Application no: H05/0892/95

Description: Remove brickwork to enable
garage door to front and patio
doors to rear to be installed

Location: The Village Hall
Hallgate
Fleet
Spalding Lincs

TOWN AND COUNTRY PLANNING ACT 1990
NOTICE OF ACCEPTANCE OF AMENDMENT

DRAWING NO.:
LS.2.B

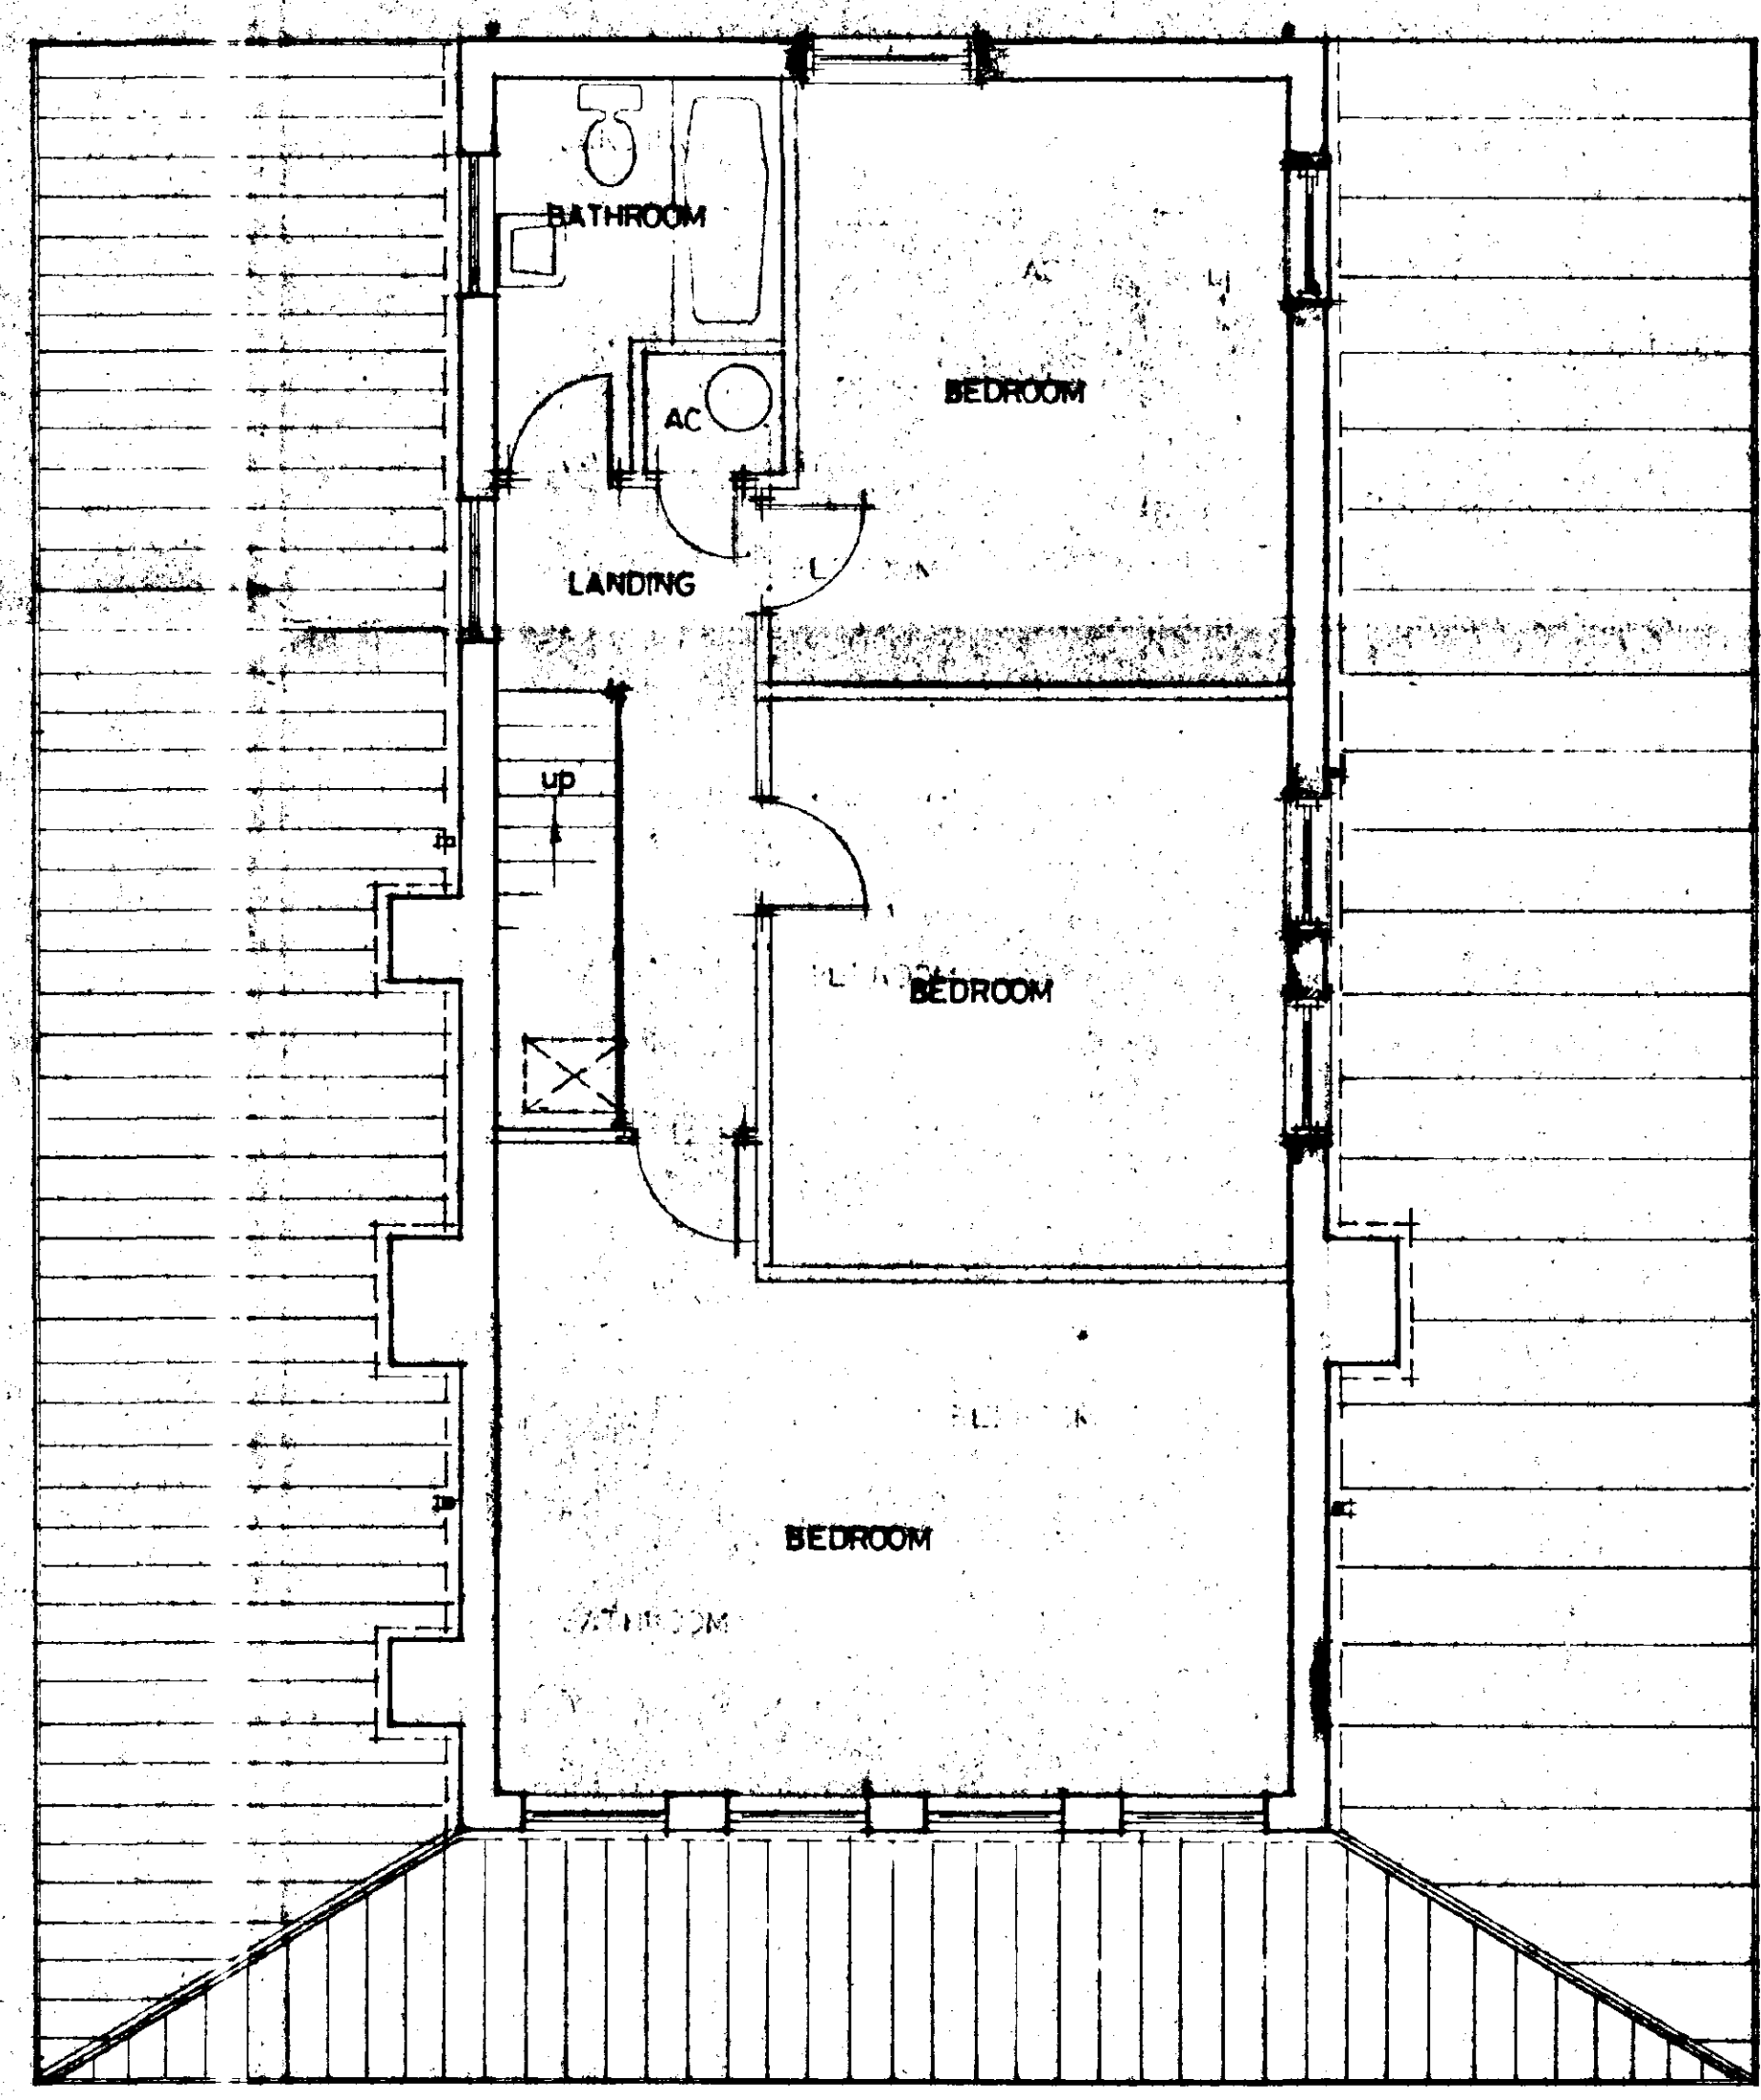
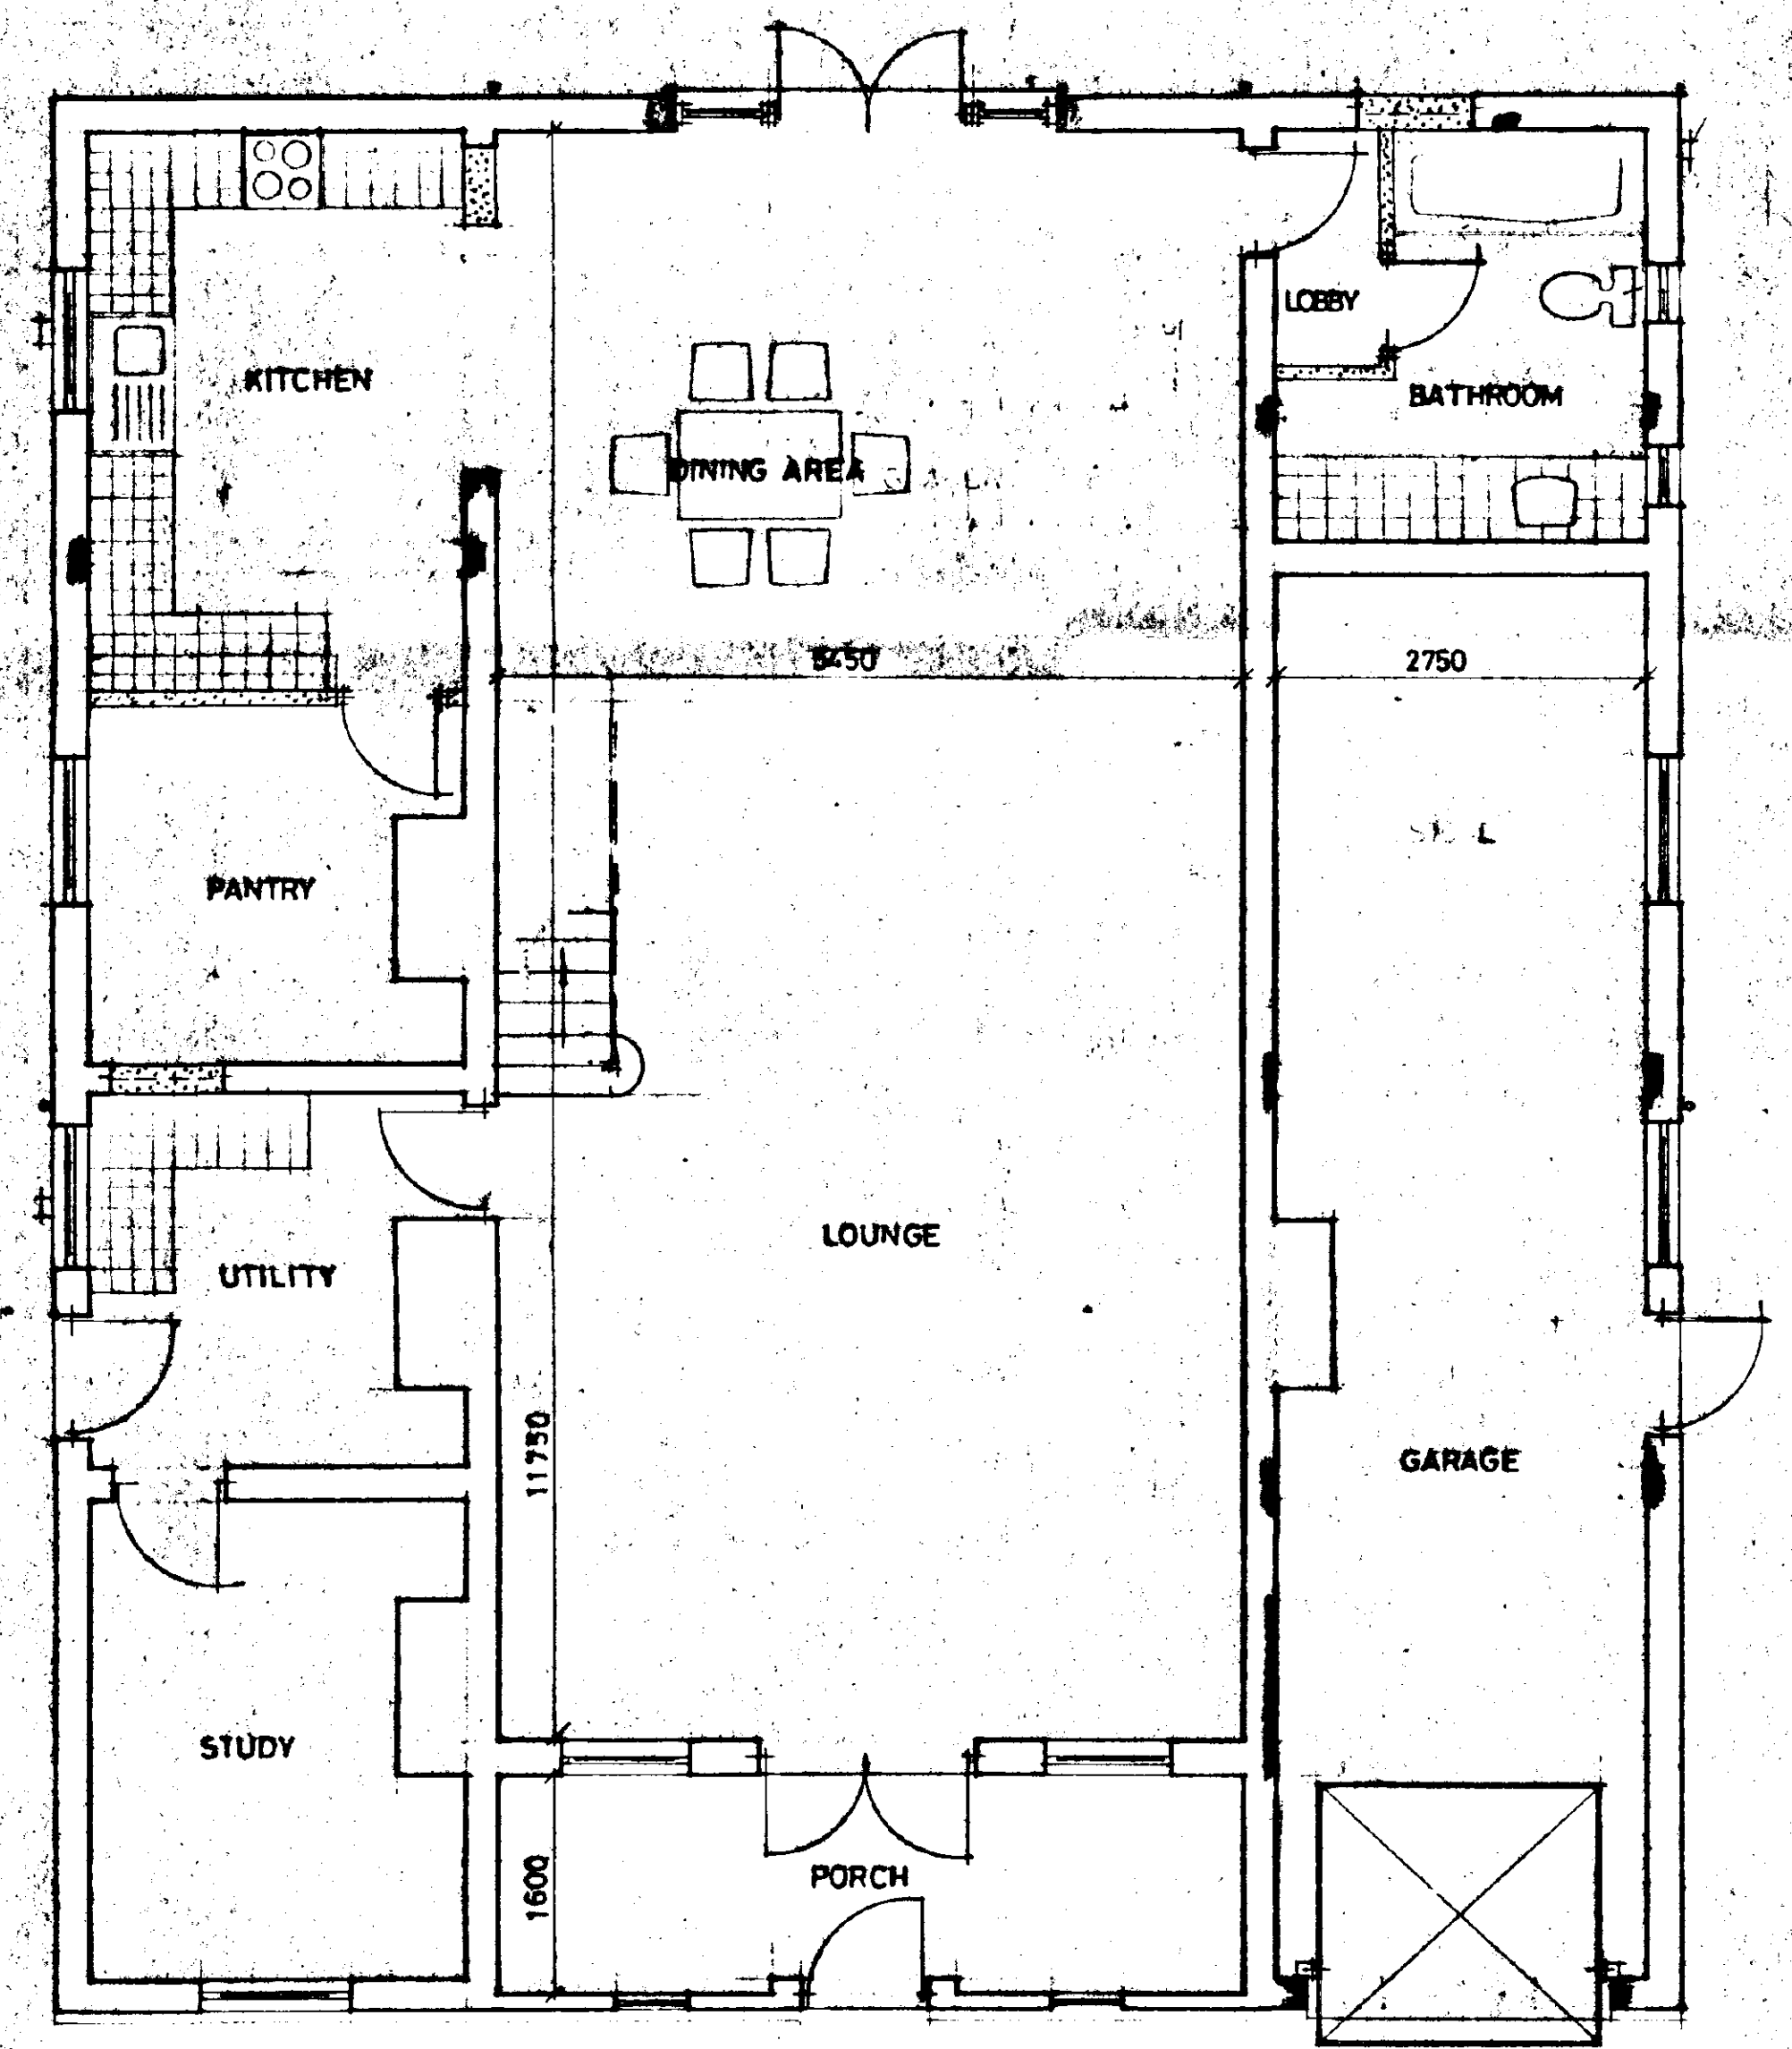
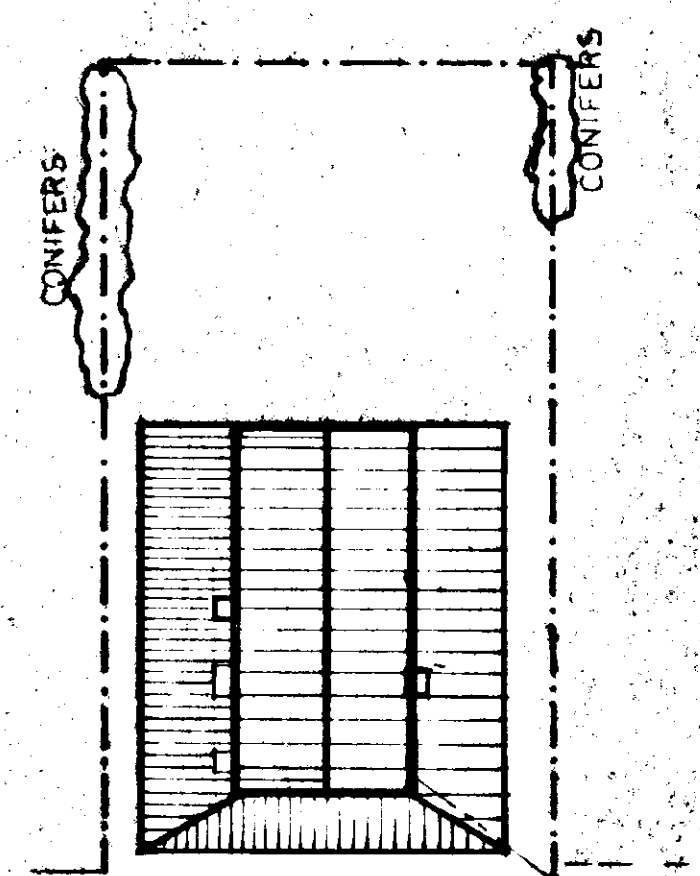
Amendment: Substitute roof windows - three windows in west elevation,
first floor, one window in rear elevation, first floor

SUBSTITUTE ROOF WINDOWS WITH.
3 NO. WINDOWS IN WEST ELEVATION, 1ST FLOOR.
1. NO WINDOW IN REAR ELEVATION, 1ST FLOOR.
REBUILD ONE CHIMNEY STACK TO EAST ELEVATION.

VELUX TYPE ROOF LIGHTS TO WEST ELEVATION WILL NO LONGER EXIST.
